A1 in Northumberland: Morpeth to Ellingham

Scheme Number: TR010059

Summary of Proposed Changes to Application

Regulation Reference:	Infrastructure Planning (Examination Procedure) Rules 2010
Planning Inspectorate Scheme Reference	TR010059
Document Reference	TR010059/7.5
Author:	A1 in Northumberland: Morpeth to Ellingham Project Team, Highways England

Type

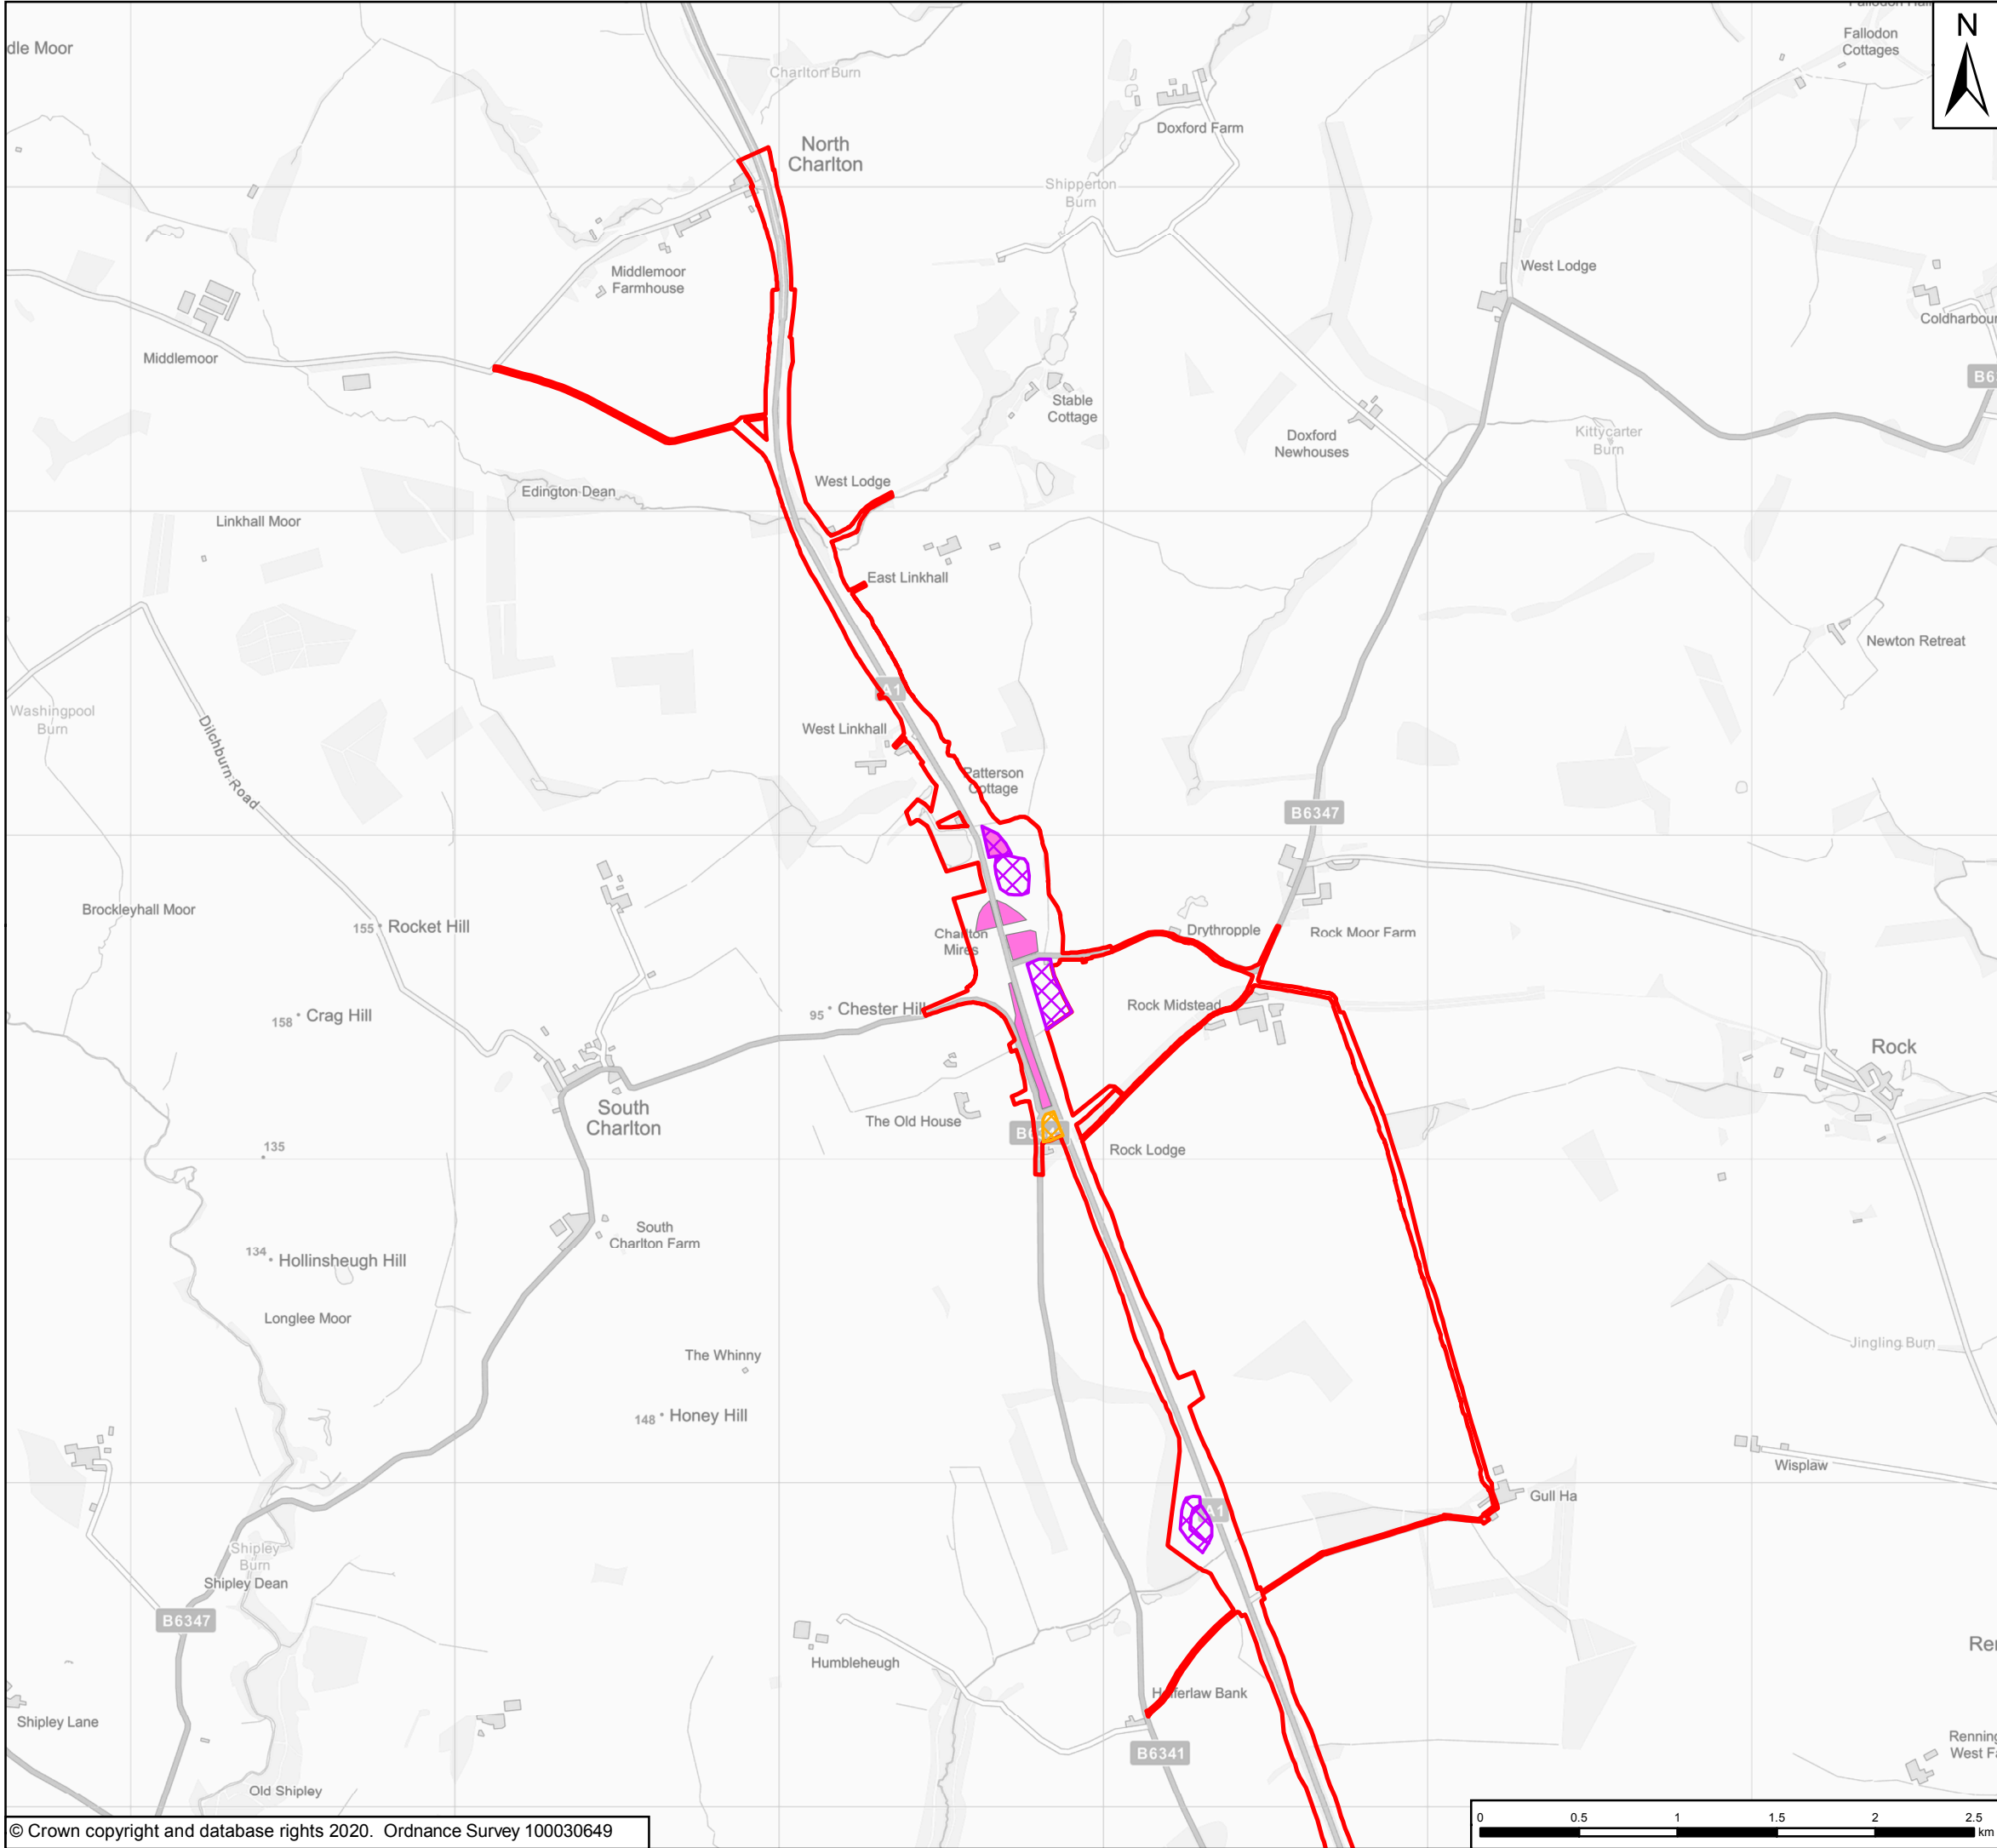
- 2.1.1 The Applicant proposes to maximise the re-use of materials (via excavation, deposition and temporary storage), within the existing Scheme extents. A recent review of the earthworks strategy has identified an opportunity to reduce earthwork movement and as a result greater flexibility in temporary and permanent storage of Site won material is required to achieve this. The indicative earthworks areas are shown in the figure in the **Indicative Earthwork Change Locations** figure in **Appendix A**.

- 2.1.2 To balance materials across both Parts A and B, the following methods are proposed:
- Utilising borrow pits to exchange and win additional material suitable for construction.

- Maximising use of soil bunds already specified within the **Figure 7.8: Landscape Mitigation Masterplan** for Part A [APP-095], **Figure 7.10 Landscape Mitigation Masterplan** for Part B [APP-144] and **Figure 7.14: Landscape Mitigation Masterplan including Assessment Parameter 3** for Part B [APP-148], for disposal of excess site material, in Part A.

- Maximising of fill within slopes, already specified within **Figure 7.8: Landscape Mitigation Masterplan** for Part A [APP-095] and **Figure 7.10 Landscape Mitigation Masterplan** for Part B [APP-144] and **Figure 7.14: Landscape Mitigation Masterplan including Assessment Parameter 3** for Part B [APP-148], for re-use of site material, in Part A.

- Creation of new soil bunds within Part B to maximise re-use of excess site material.
 - Maximising of slopes for re-use of excess site material, in Part B.

- Laying down additional material increasing some localised ground levels.
 - Raising levels of junction “bowls” (level or rounded rather than dished).

- Creating new, temporary soil storage areas within both Part A and Part B.
- 2.1.3 These changes are an alteration to Parameters 4 and 5 for Part A, as set out in **Chapter 2: The Scheme** of the ES [APP-037]. There would also be additional temporary and permanent earthworks that require assessment for Part A and Part B. Therefore, it is appropriate to ensure that the environmental information before the Examination addresses the prospect of altered impacts This is addressed by sensitivity testing as described at **paragraph 2.1.6** below.

Temporary Works at the River Coquet

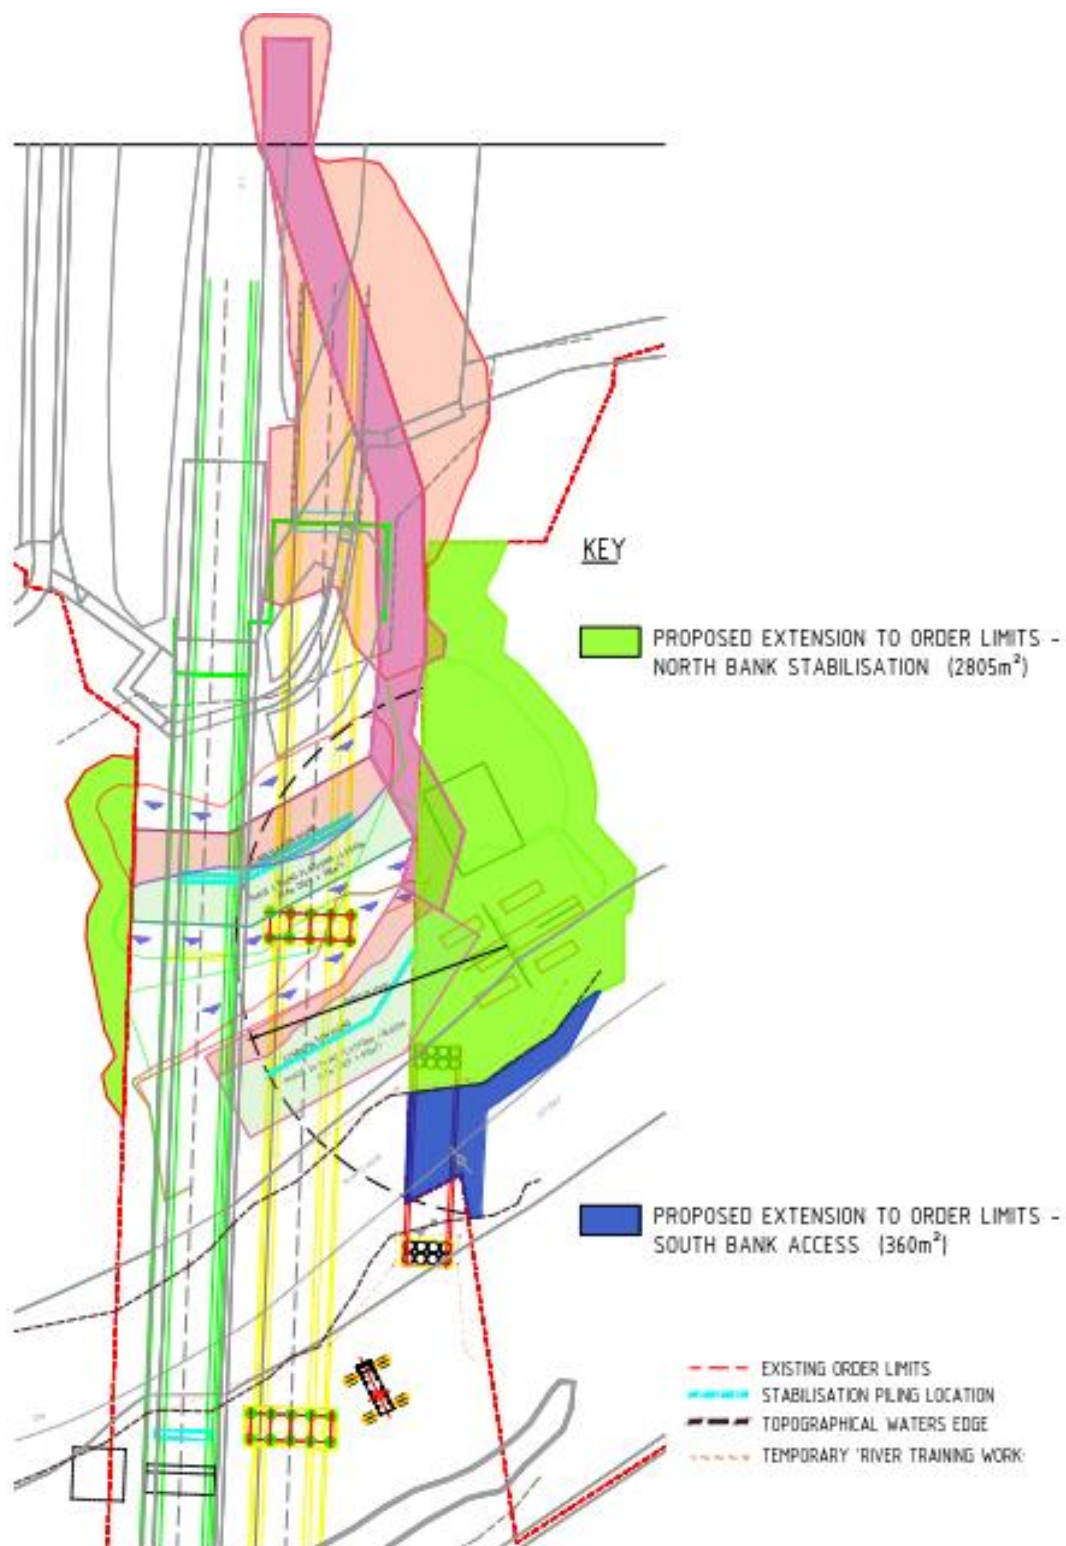
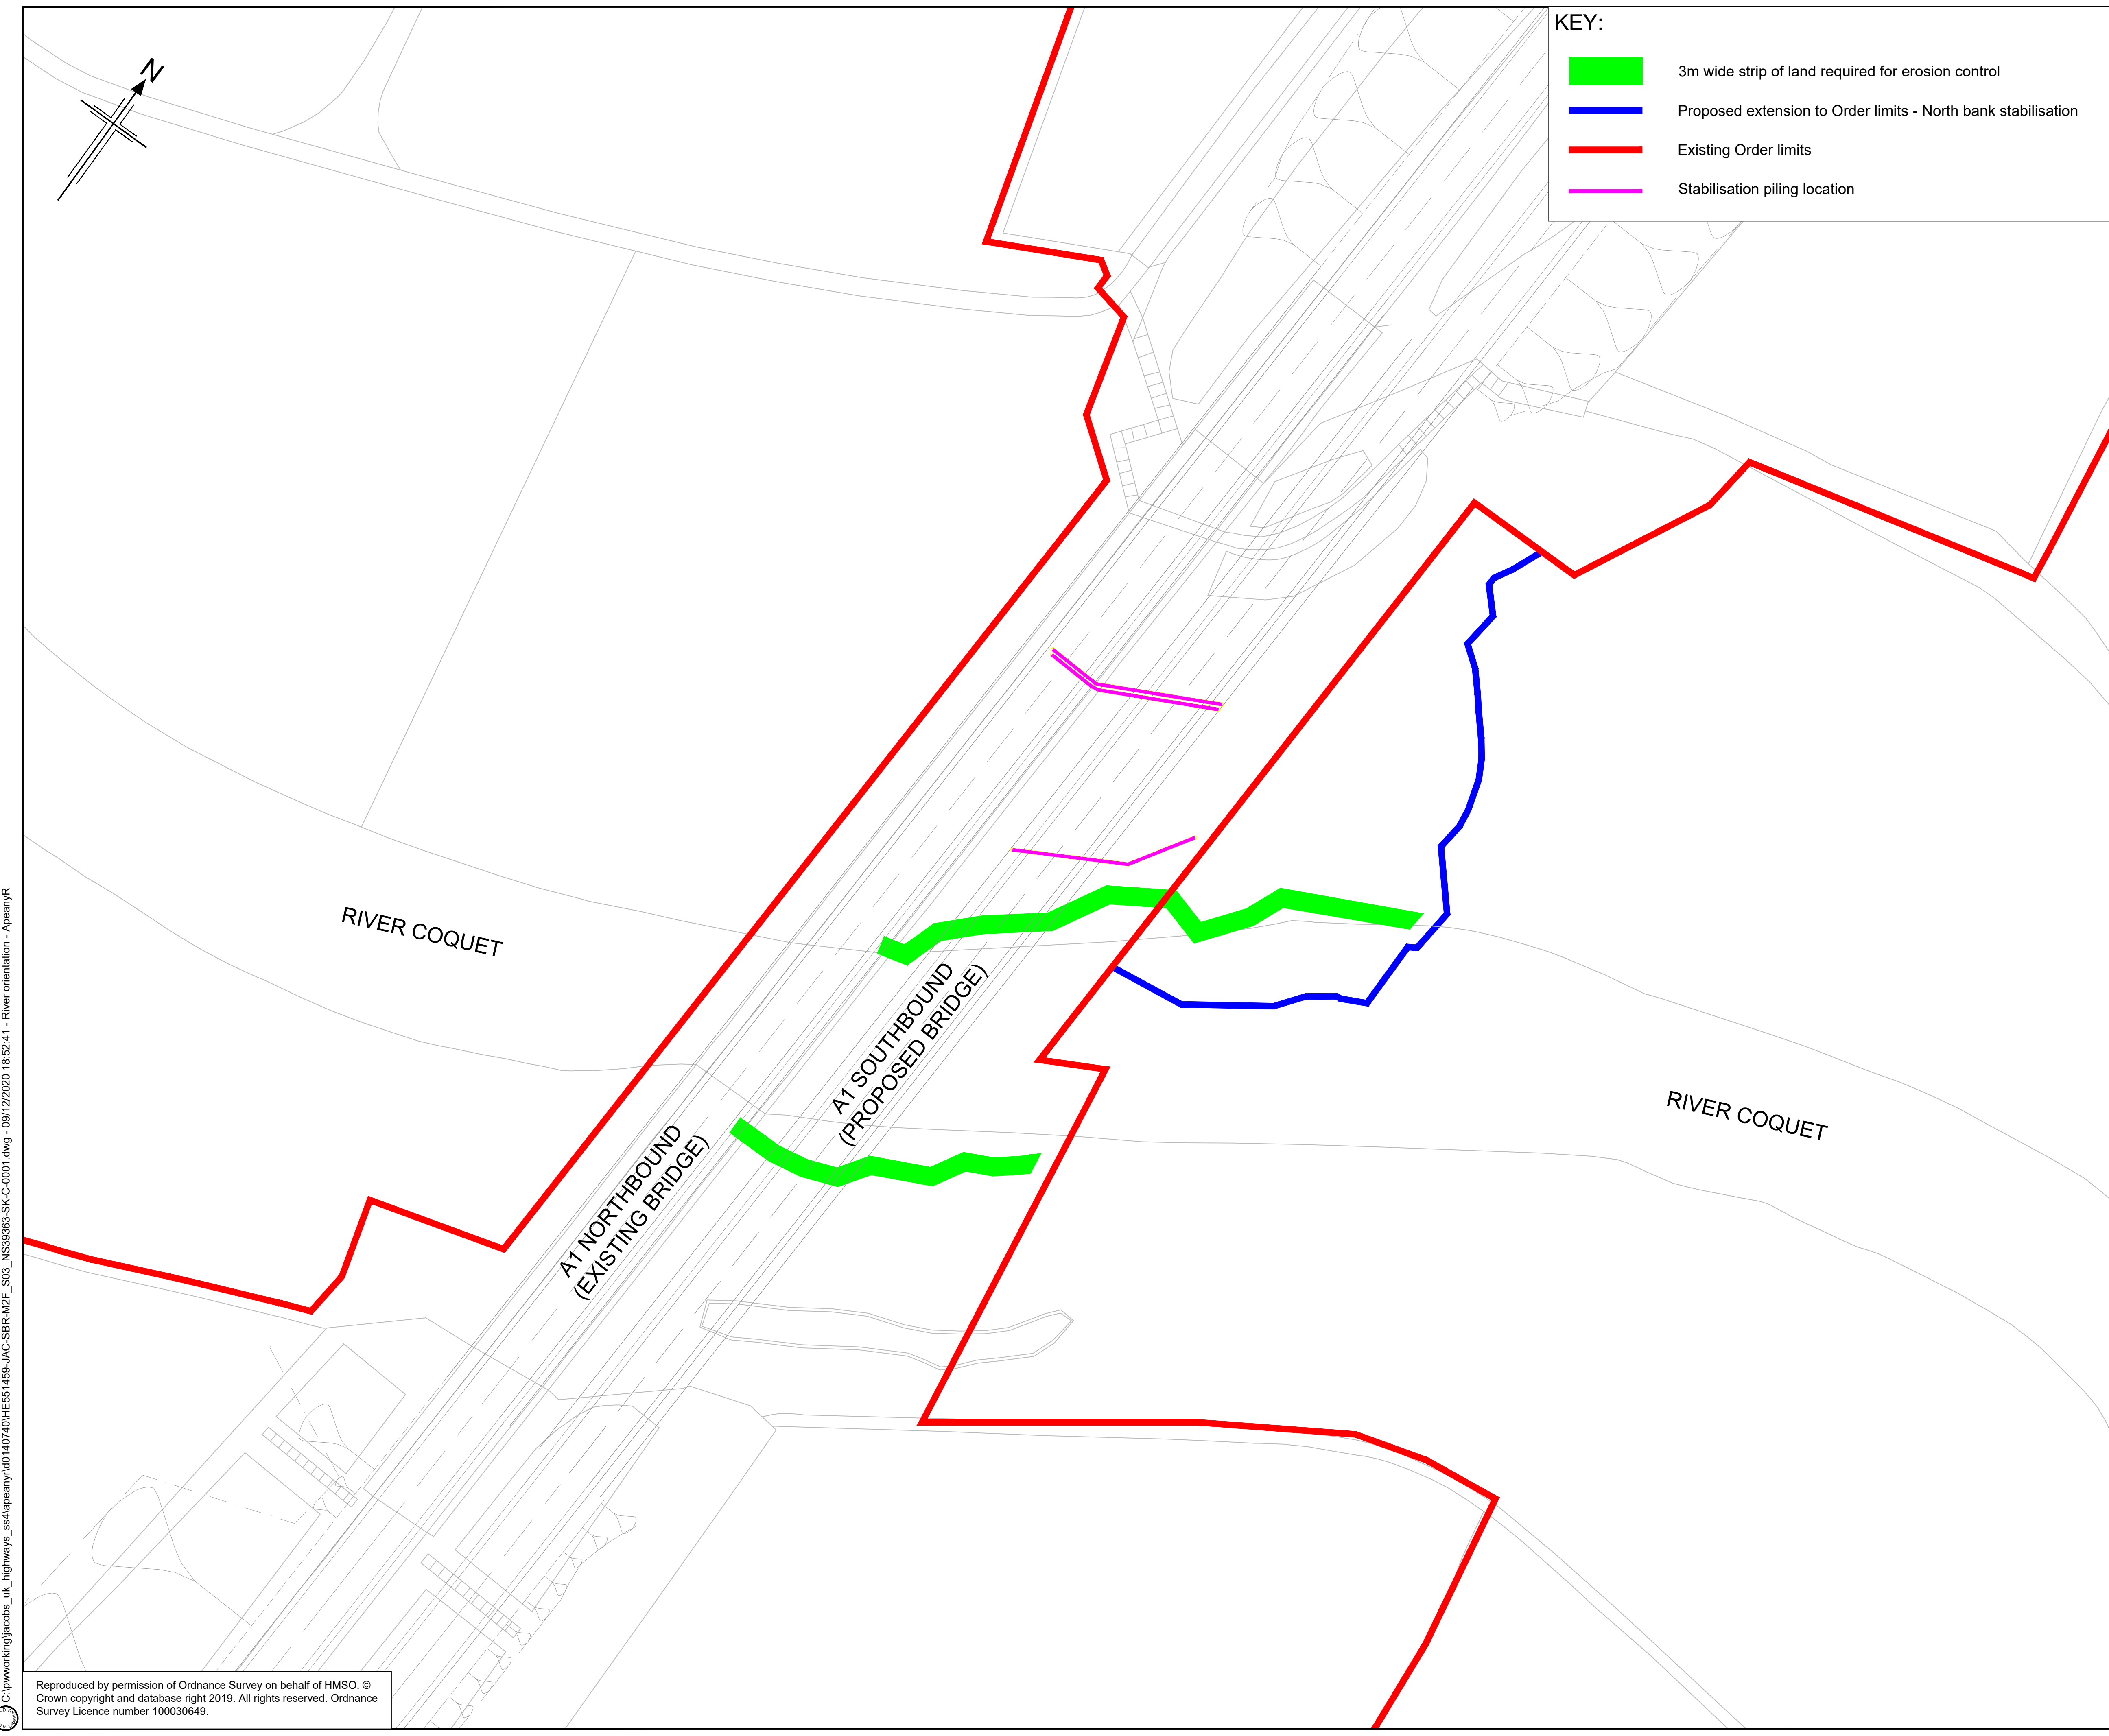
2. Works on the north bank of the River Coquet in order to stabilise the proposed bridge and existing bridge within Part A. The stabilisation works would include the installation of piles in the north bank of the River Coquet and the installation of erosion protection measures on the river bank. Land outside the Order limits would temporarily be required as a working area for the installation of the piles and access to works, as well as for the carrying out of the erosion protection

measures. As the installation works would lead to the loss of woodland within the Coquet River Felton Park Local Wildlife Site (LWS), there may also be a requirement for additional compensatory habitat outside the Order limits. Permanent erosion protection measures are proposed on the north bank (including outside the existing Order limits) and on the south bank.

3. Provision of a temporary access to the south bank of the River Coquet is proposed by crossing the river from the temporary works on the northern bank. It is anticipated that this would result in improved environmental performance in terms of access that would otherwise be provided from the South bank itself. The engineering solution for such a crossing is to use of a temporary bridge to span over the river. It is anticipated that there would also be some temporary river training works along each riverbank and additional erosion protection to the southern pier of the new bridge. Additional temporary rights would be required for the installation of the temporary bridge.
